## Department of Energy

November 9, 2007

Subject: Starlite Heights Preliminary Plat (P-07-16)  
BPA Reference: Schultz-Raver Corridor

SITE PLAN
OF
STARLITE HEIGHTS
A PORTION OF SECTION 01, TOWNSHIP 19 N., RANGE 14 E., W.M.
KITTITAS COUNTY, WASHINGTON

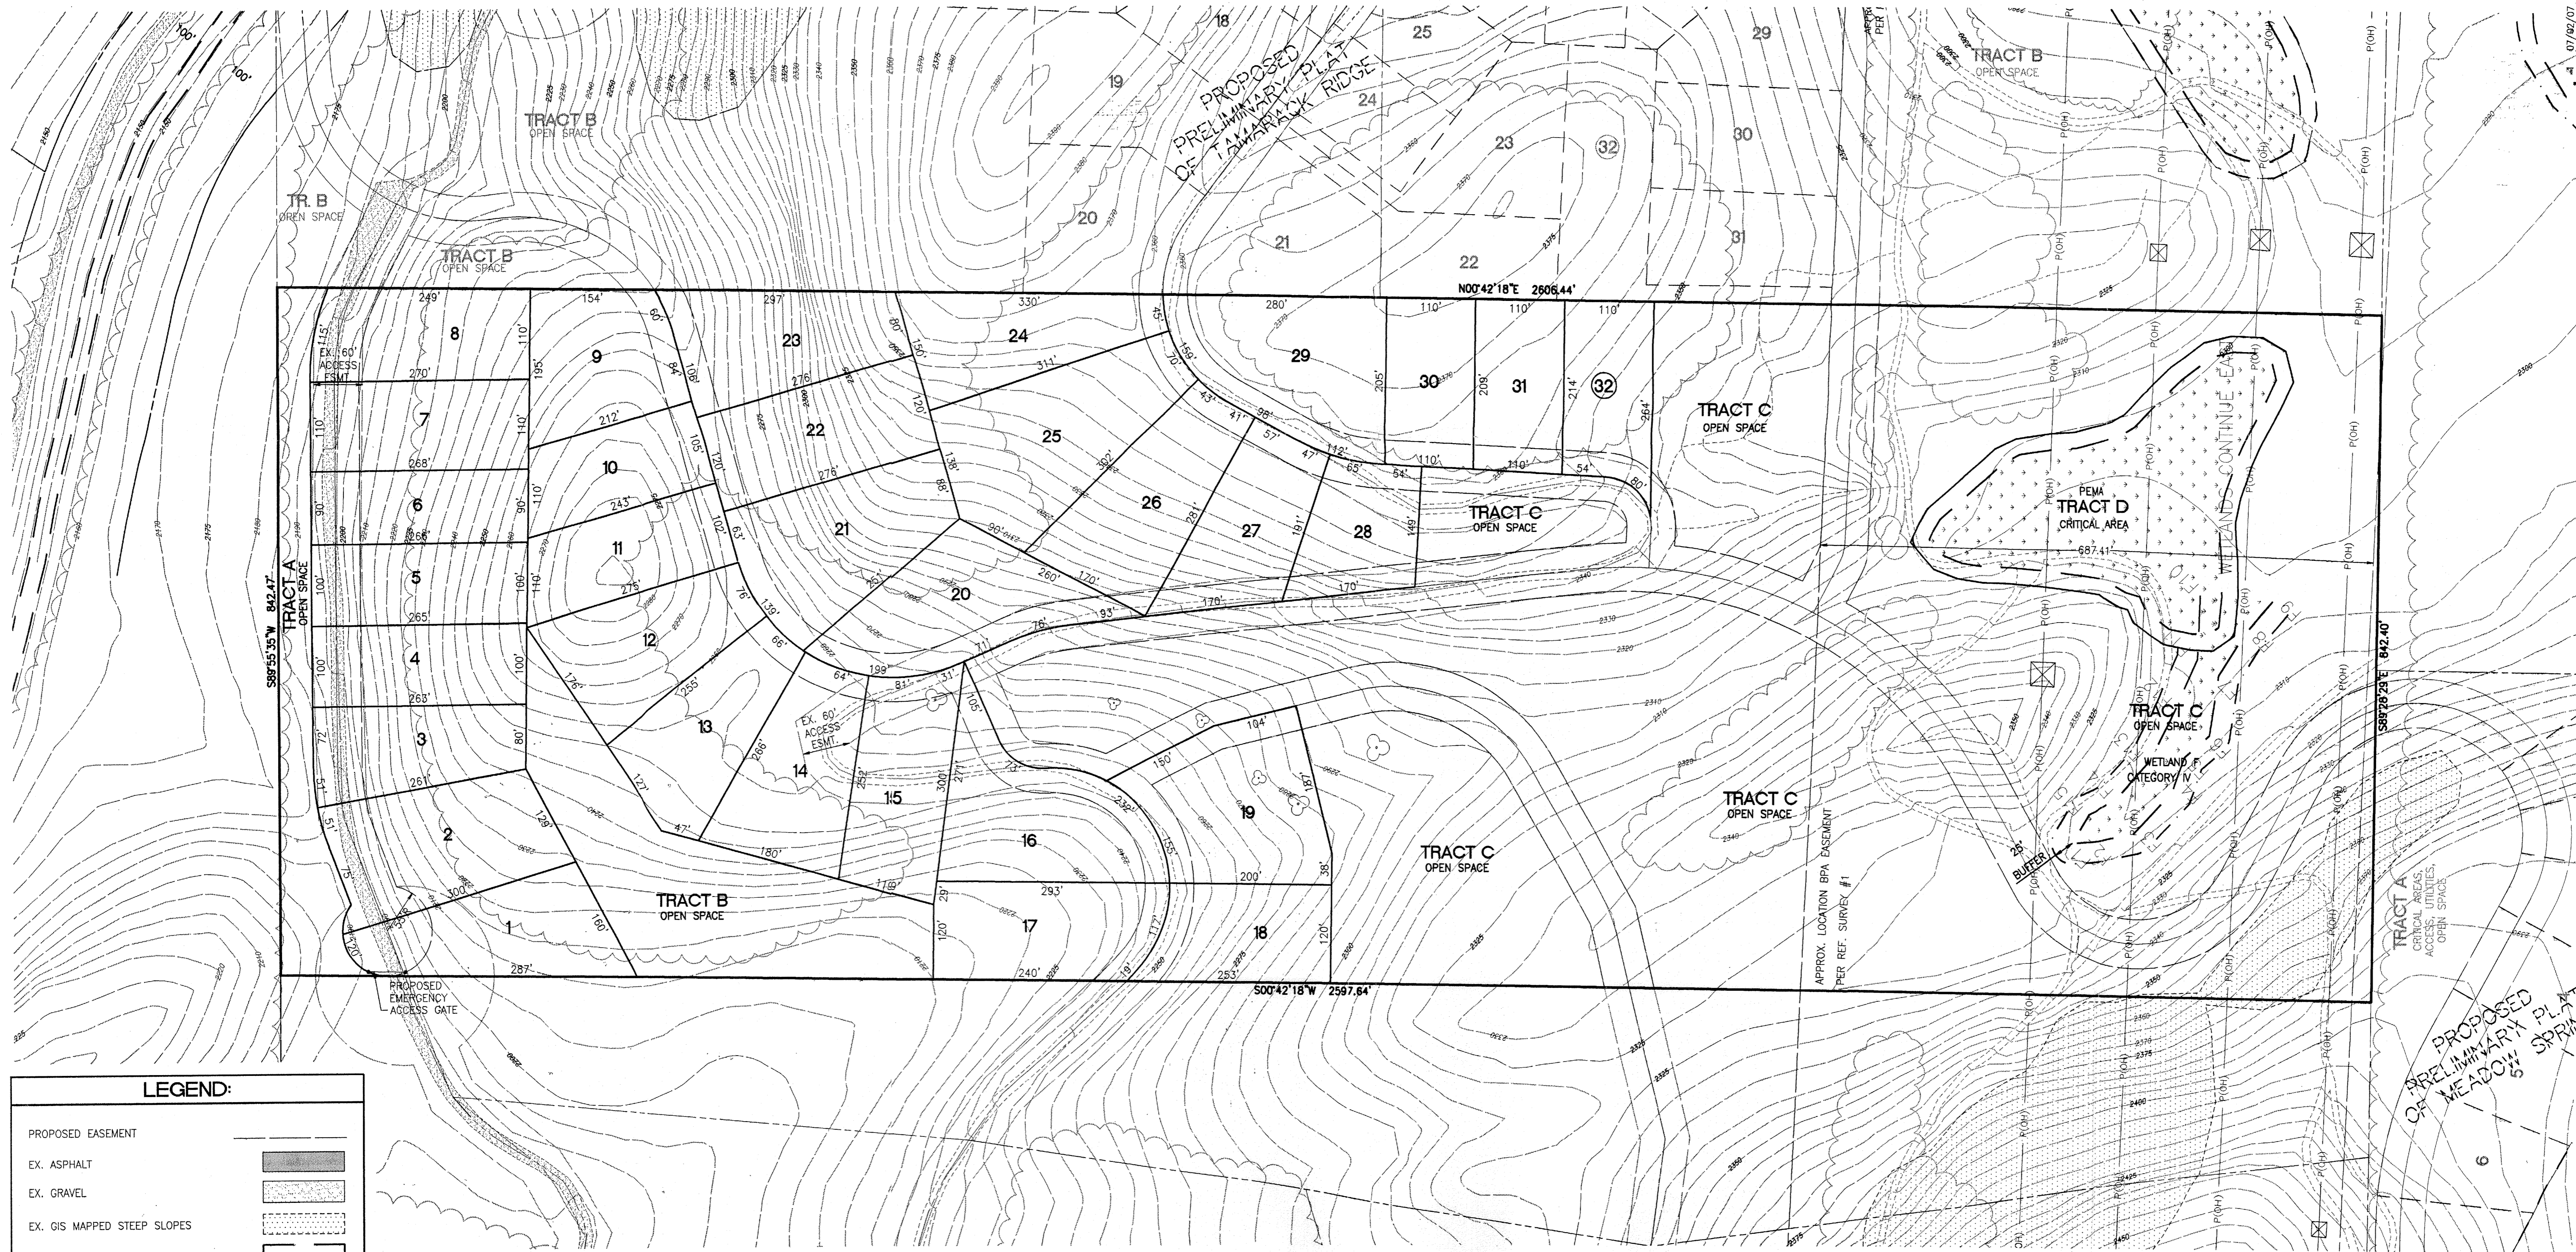
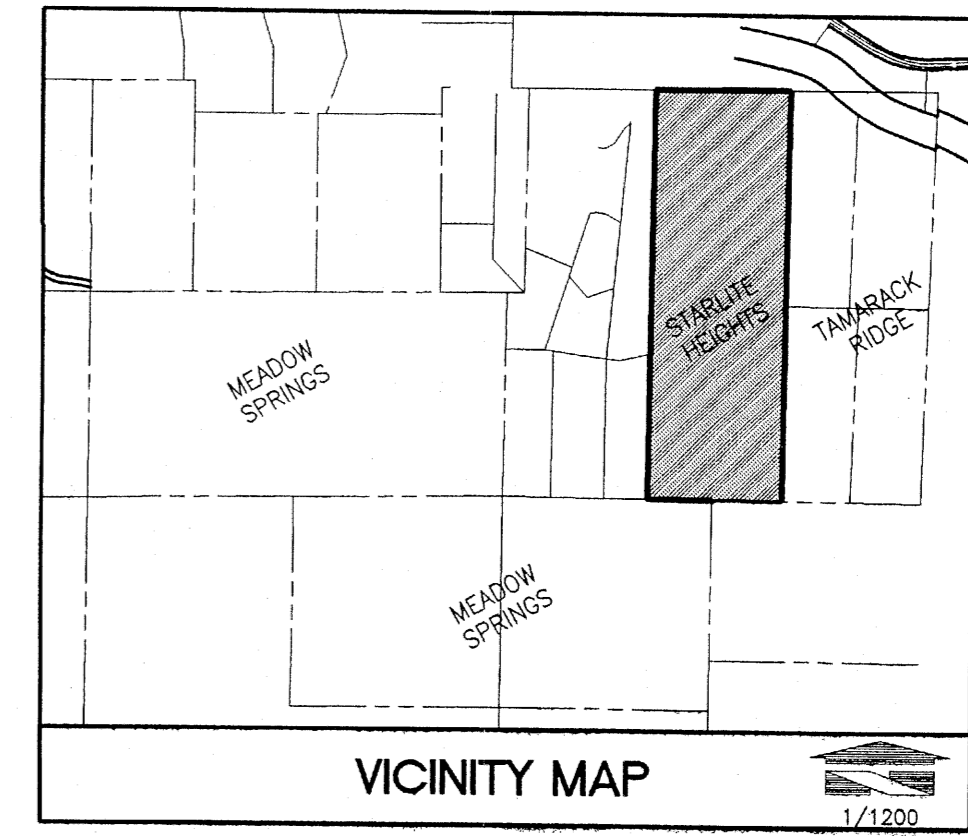
The Starlite Heights plat appears to have one piece of road crossing almost perpendicular and a portion which runs longitudinally along the northern edge of the easement. Although this portion of the corridor is currently unoccupied, should BPA install a line there in the future, there is a good chance that this road would cause safety issues and could not be allowed.

The developer of this subdivision will need to submit a land use application to BPA indicating the location of any facilities, activities, or property lot lines which will be located within the transmission line corridor. Their application should indicate distances from the nearest tower and be as clear and descriptive as possible. Grading plans should also be provided as grade changes can severely impact the safety of both the public and BPA's personnel working on its facilities. This application can be found on the BPA website at ([www.transmission.bpa.gov/LanCom/Real\\_Property.cfm](http://www.transmission.bpa.gov/LanCom/Real_Property.cfm)). Please note that there is a \$250 application fee associated with this application and the review process typically takes 8-10 weeks. Upon review and approval of their application, BPA will issue a Land Use Agreement which will be copied to you so that you are notified of the conditions/requirements in which their development activities can be performed safely within the BPA transmission line corridor.
